Our reference: ECM: 9783432  
Contact: Kathryn Saunders  
Telephone: (02) 4732 8567

12 November 2021

**Request for Advice – Request for Further Information for Oakdale West Estate Stage 3 - SSD-9794683 at 2 Aldington Road Kemps Creek**

L.SK.201

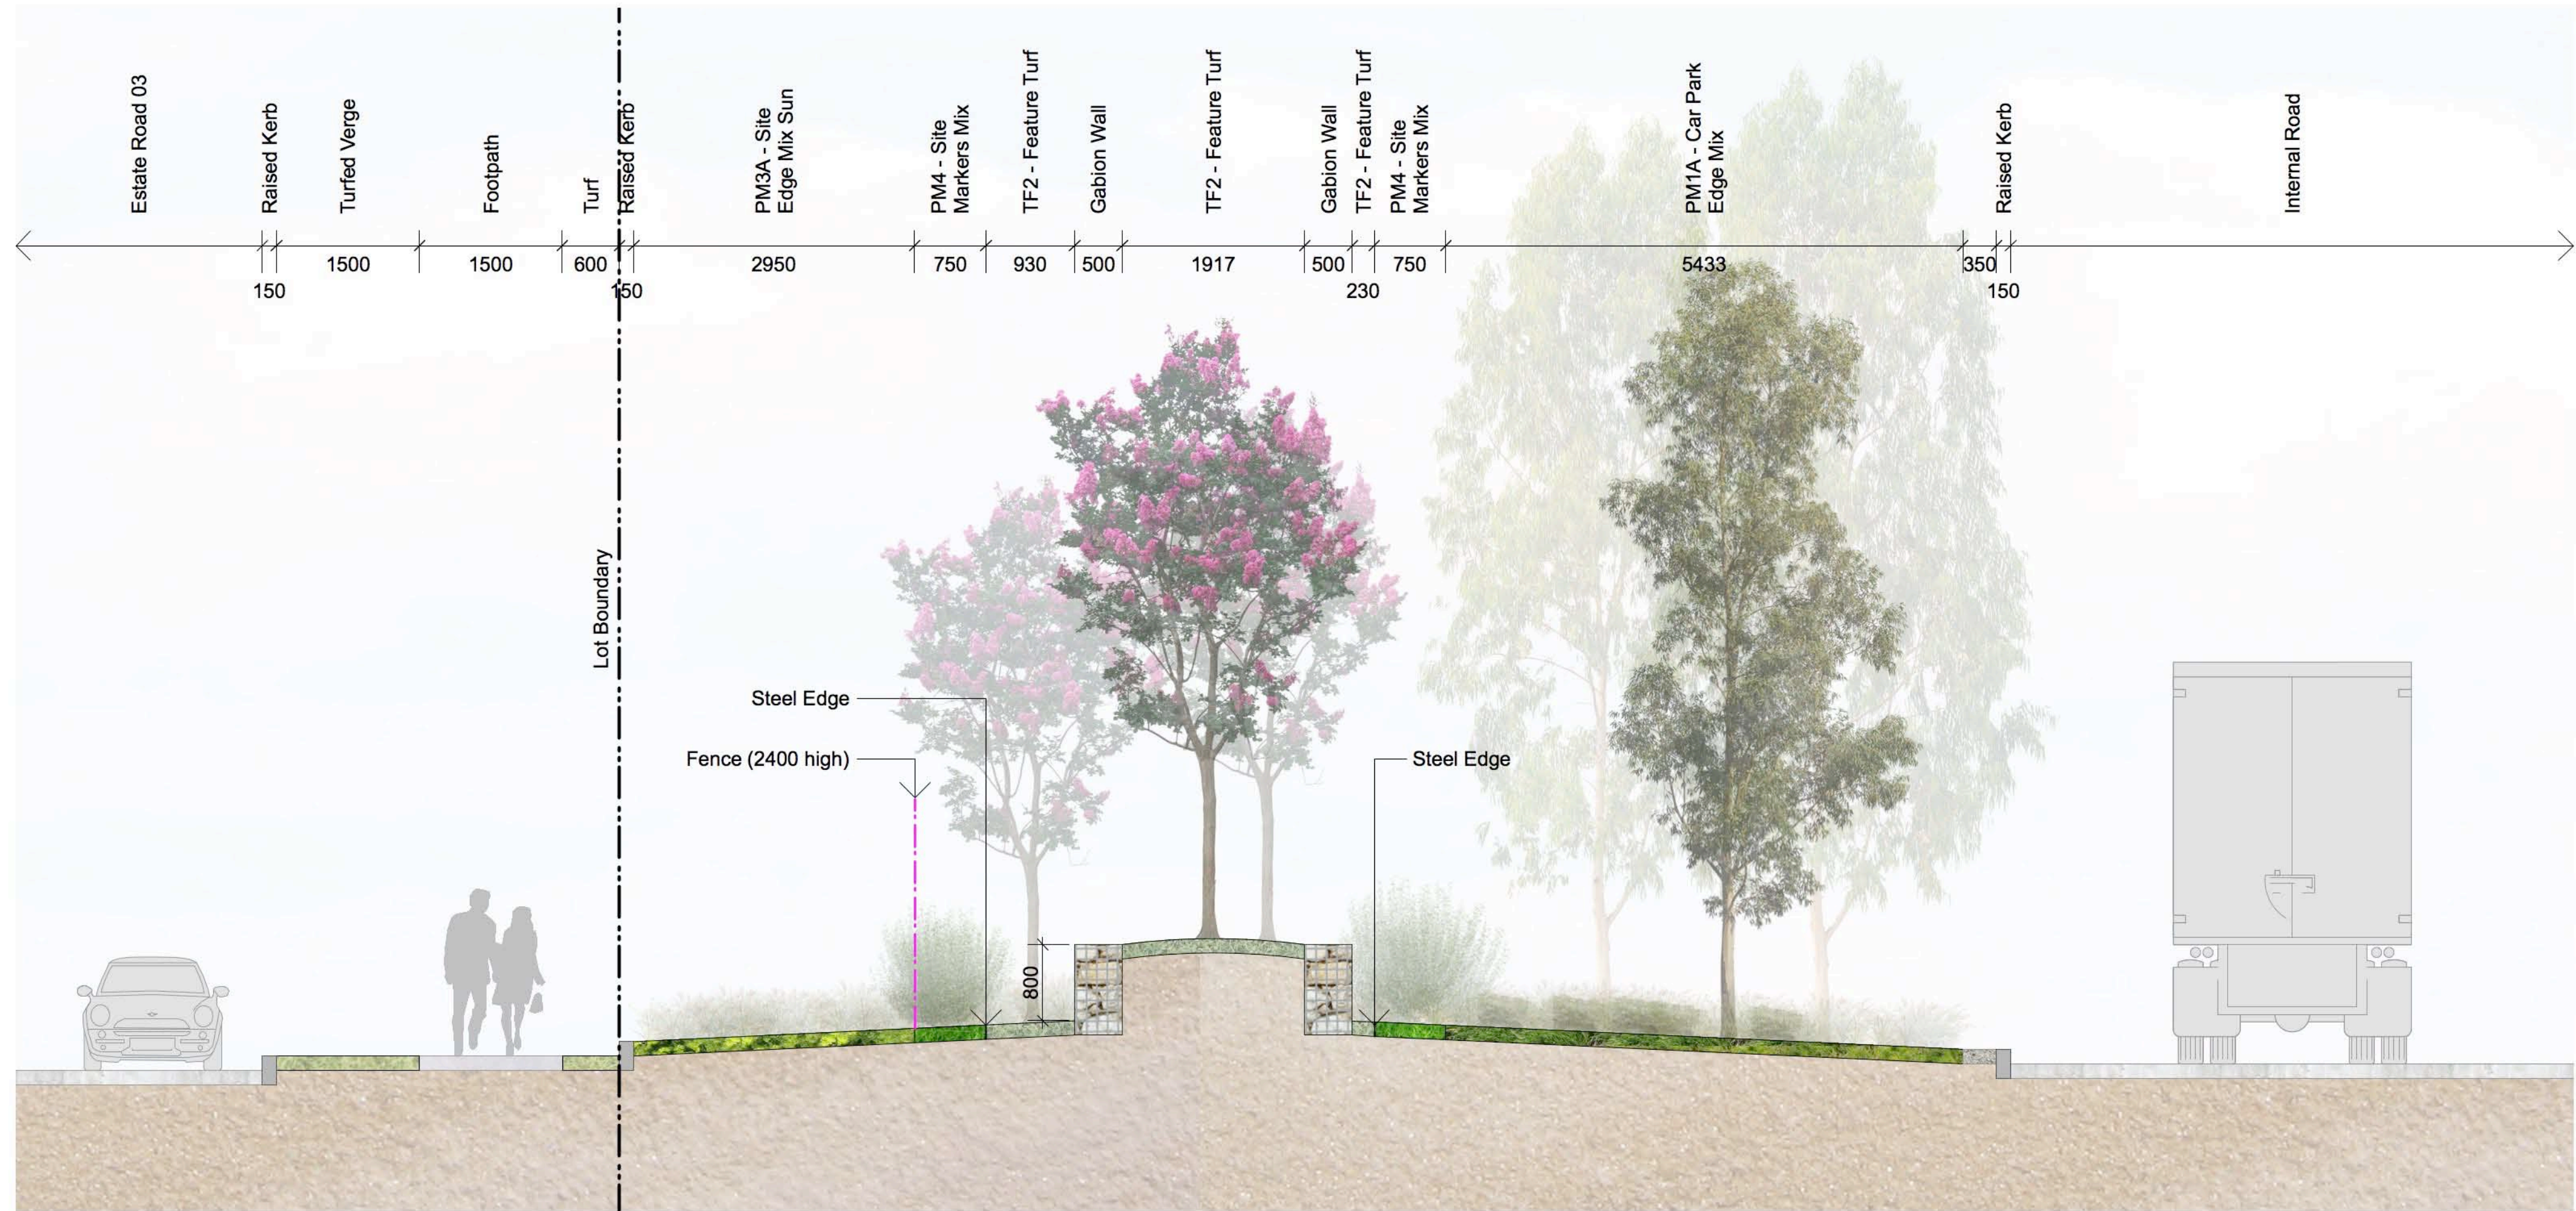
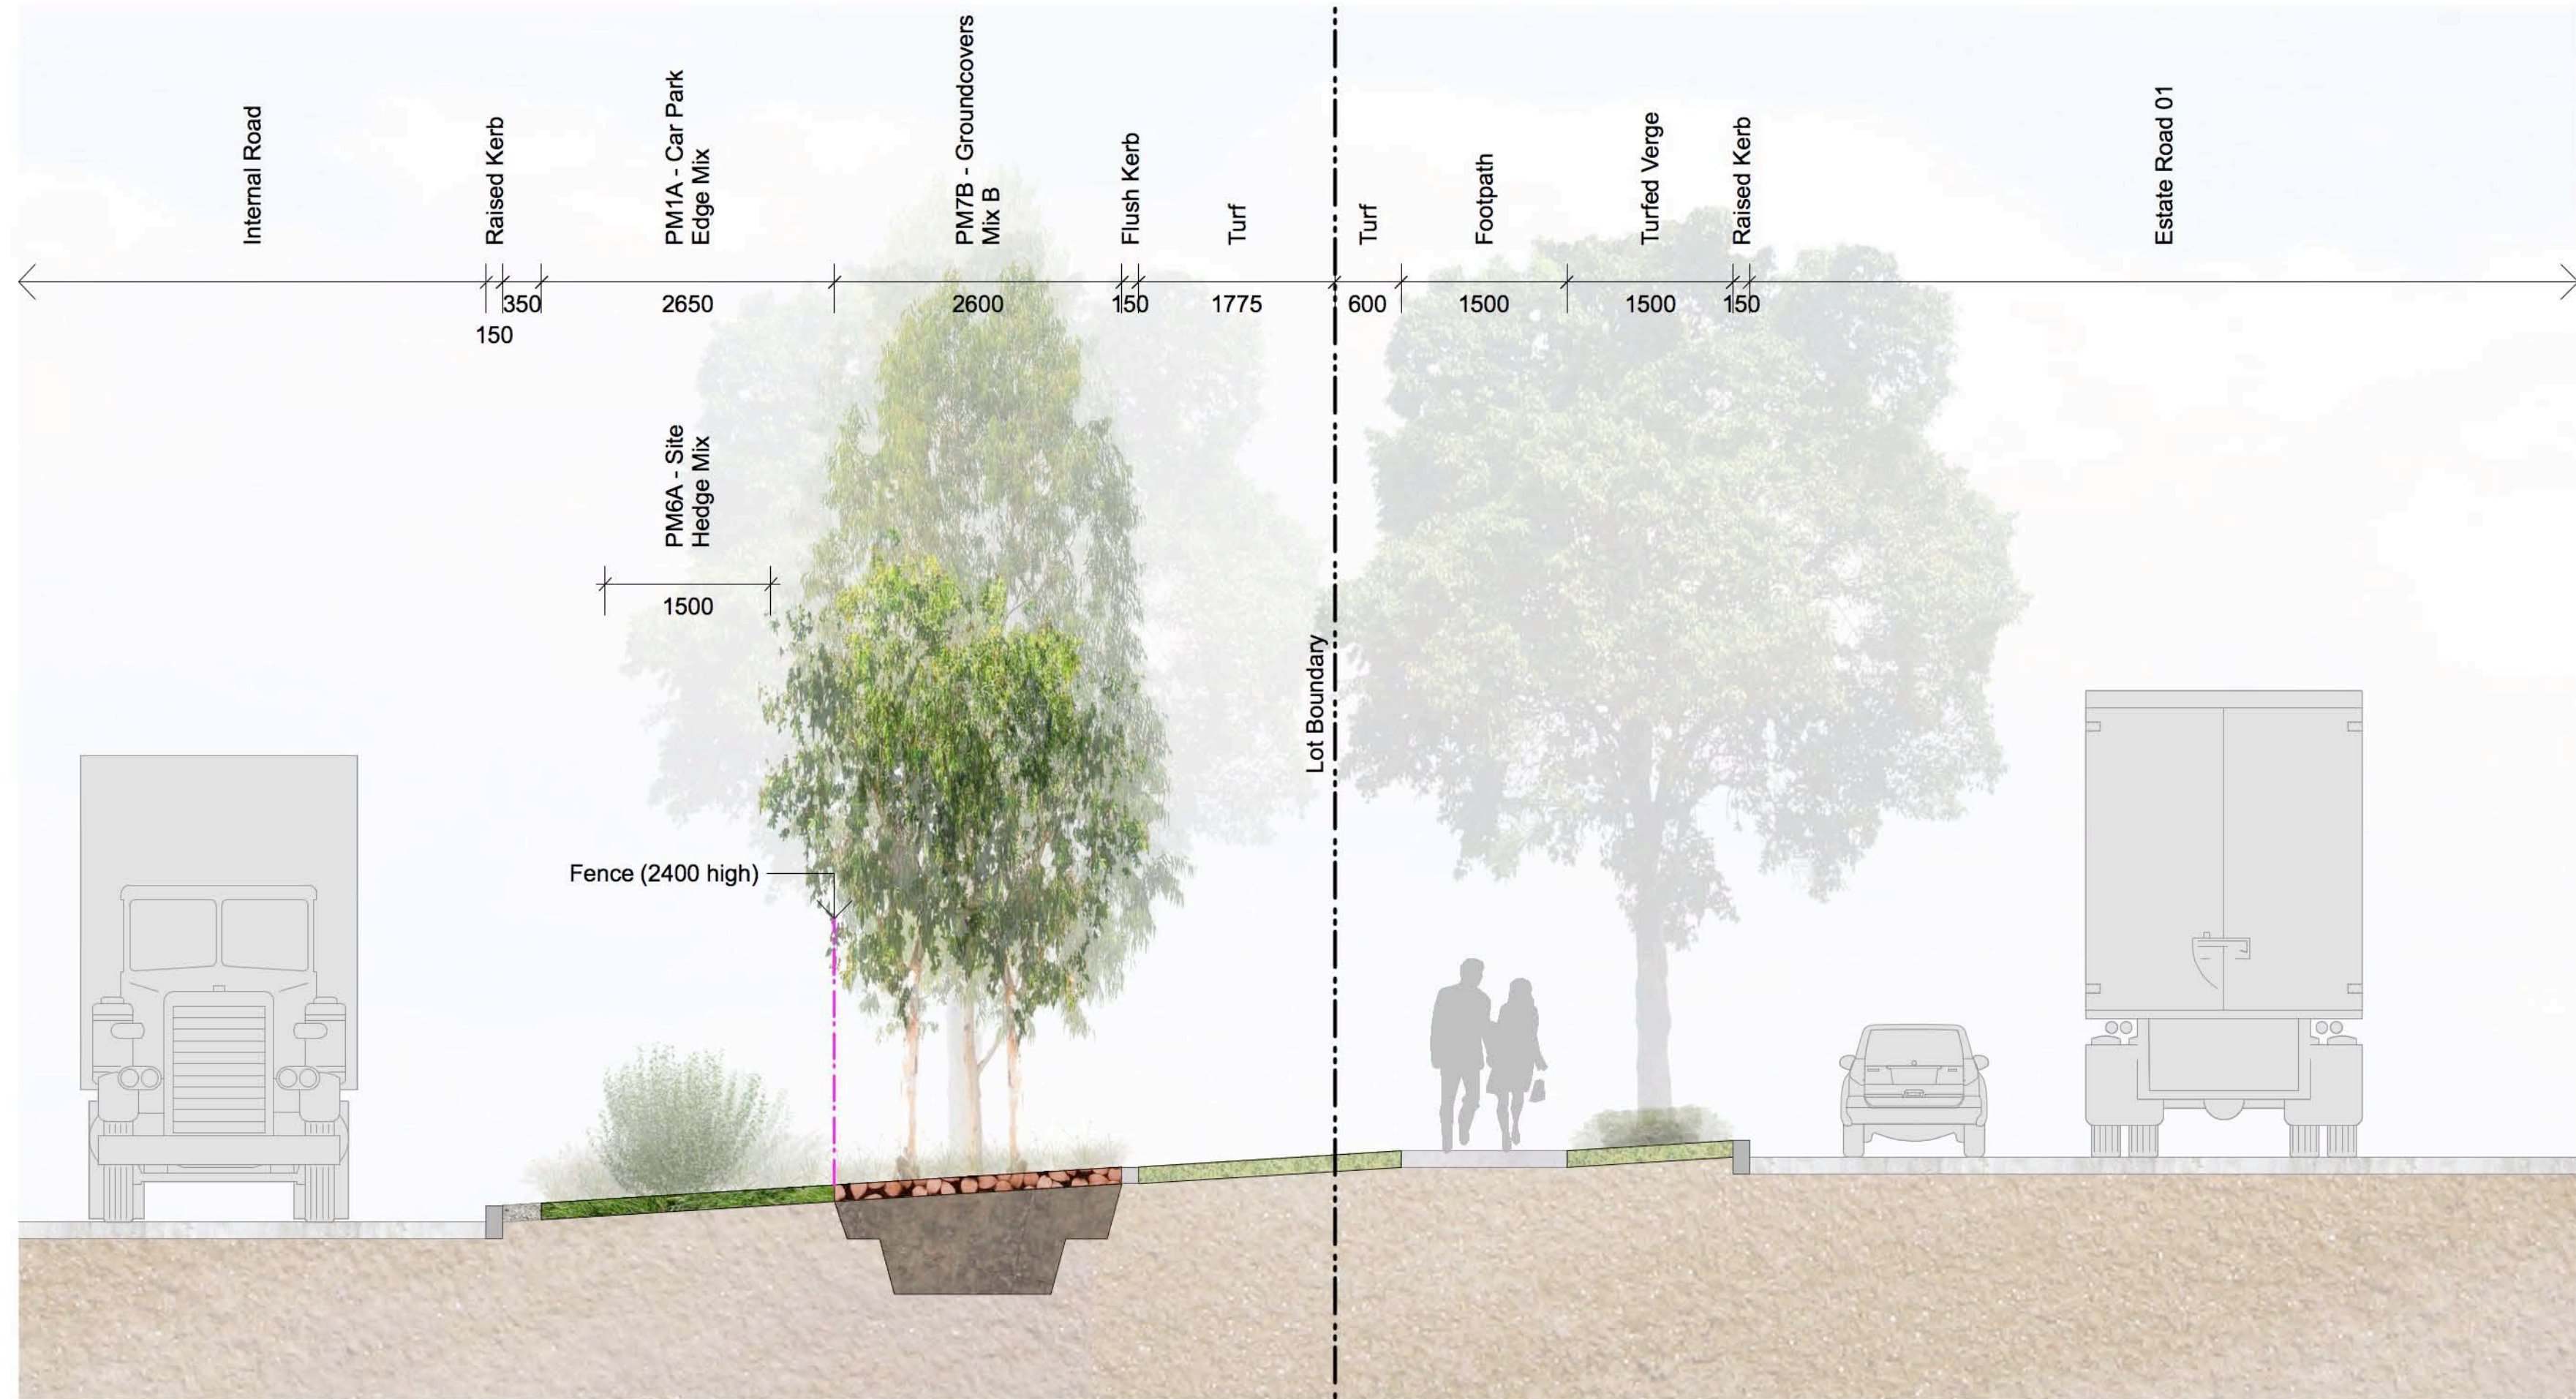
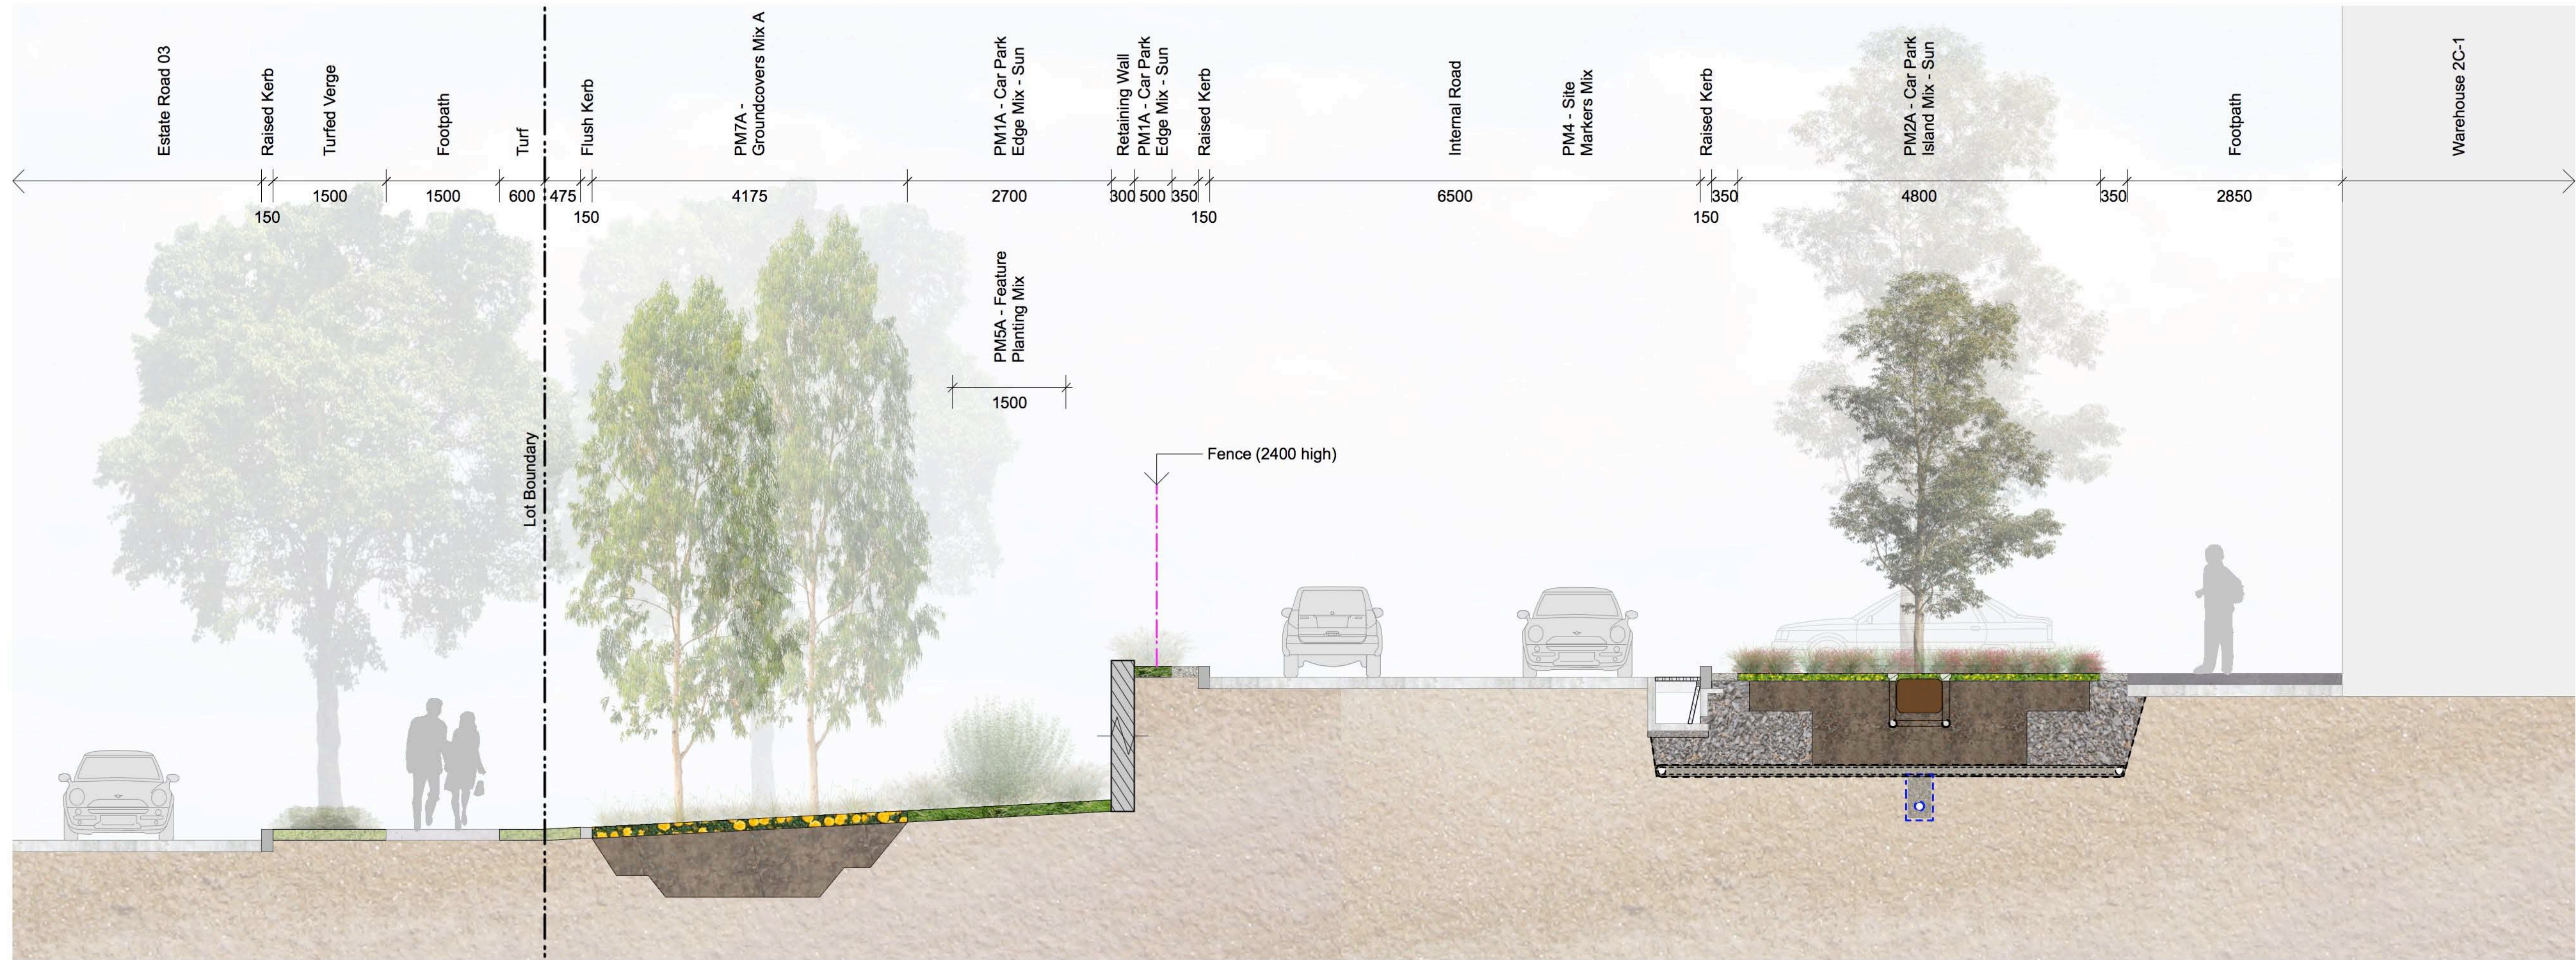
- With respect to the raised feature treatments with gabion walls, an arborist must inform and determine suitable dimensions of soil volumes and other treatments to ensure the best possible growing conditions for long term tree and plant health and viability (refer sheet LSK.201)
